**Case Officer:** Shona King

**Recommendation:** Permitted

**Proposal:** Discharge of Conditions 6 (driveway, parking and manoeuvring areas) & 7 (ground/floor levels) of 19/02001/F

SITE PLAN
(Scale 1:200)

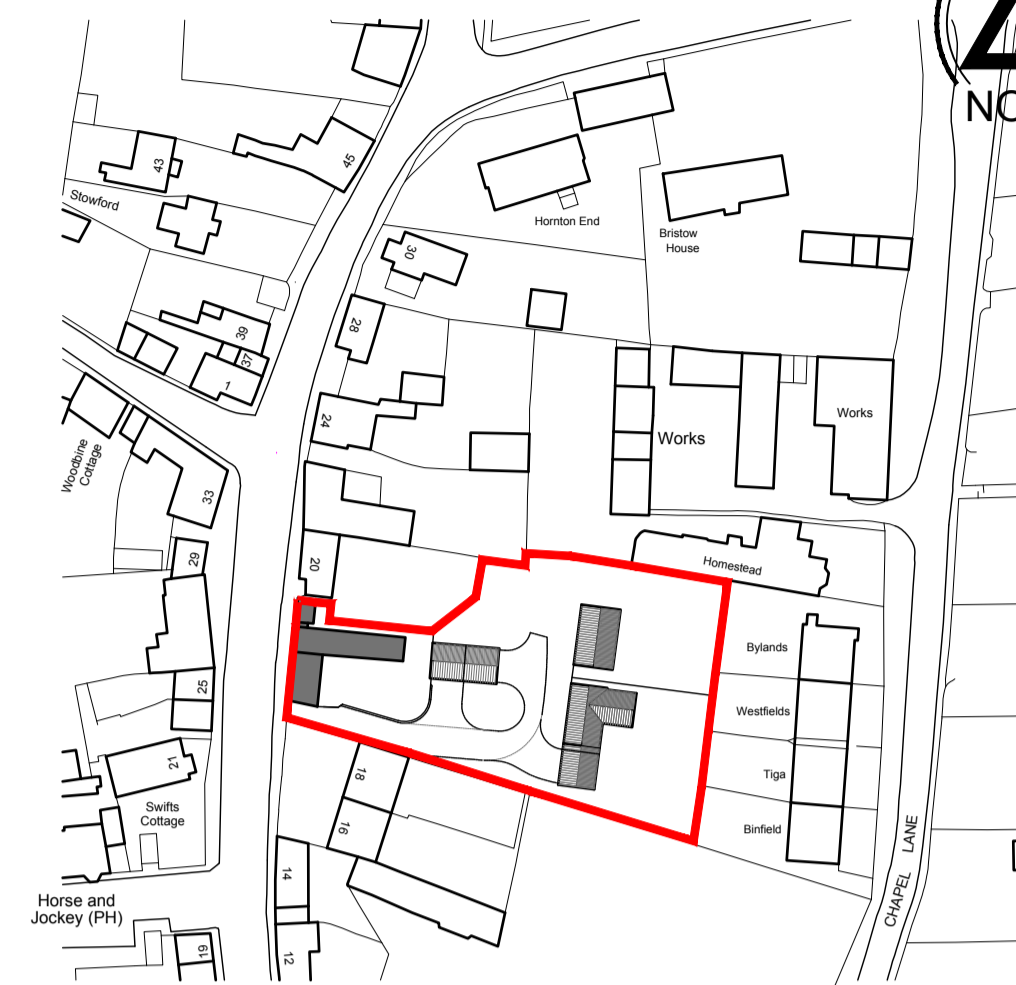
- 4.1. OCC HIGHWAY AUTHORITY: The manoeuvring areas for this development are adequate, however the garage space for both plot 1 and 2 are not large enough to be considered sufficient vehicle parking spaces. OCC's Street Design Guide states that for a garage to be adequate parking it must measure 3m x 6m and a double garage 6m x 6m, the garages will therefore need to be amended to ensure they are fit for purpose.

- 5.1. Condition 6 requires the approval of specification details of the driveway, parking and manoeuvring areas. The Local Highway Authority (LHA) has commented that

the manoeuvring areas for this development are adequate but the garage space for plots 1 and 2 are not large enough to be considered sufficient vehicle parking spaces. These garage sizes were approved under the enabling consent (19/02001/F) and at that time the LHA did not object. At least two spaces are available for parking purposes on the drives to allow for turning without the use of the garages. Condition 6 only required the specification of the driveway, parking and manoeuvring areas and not the size of the garage spaces. Therefore, as there are no objections to this, it is considered that the details are acceptable.

- 5.2. Condition 7 requires the approval of the existing and proposed ground levels and finished floor levels of the development. The finished floor levels of the dwellings are approximately 10cm above the existing ground levels with the garage floor levels much lower than this. It is considered that the finished levels would not result in harm to the character and appearance of the area, the significance of heritage assets or the living conditions of neighbouring residents and future occupiers of the development and are therefore acceptable.
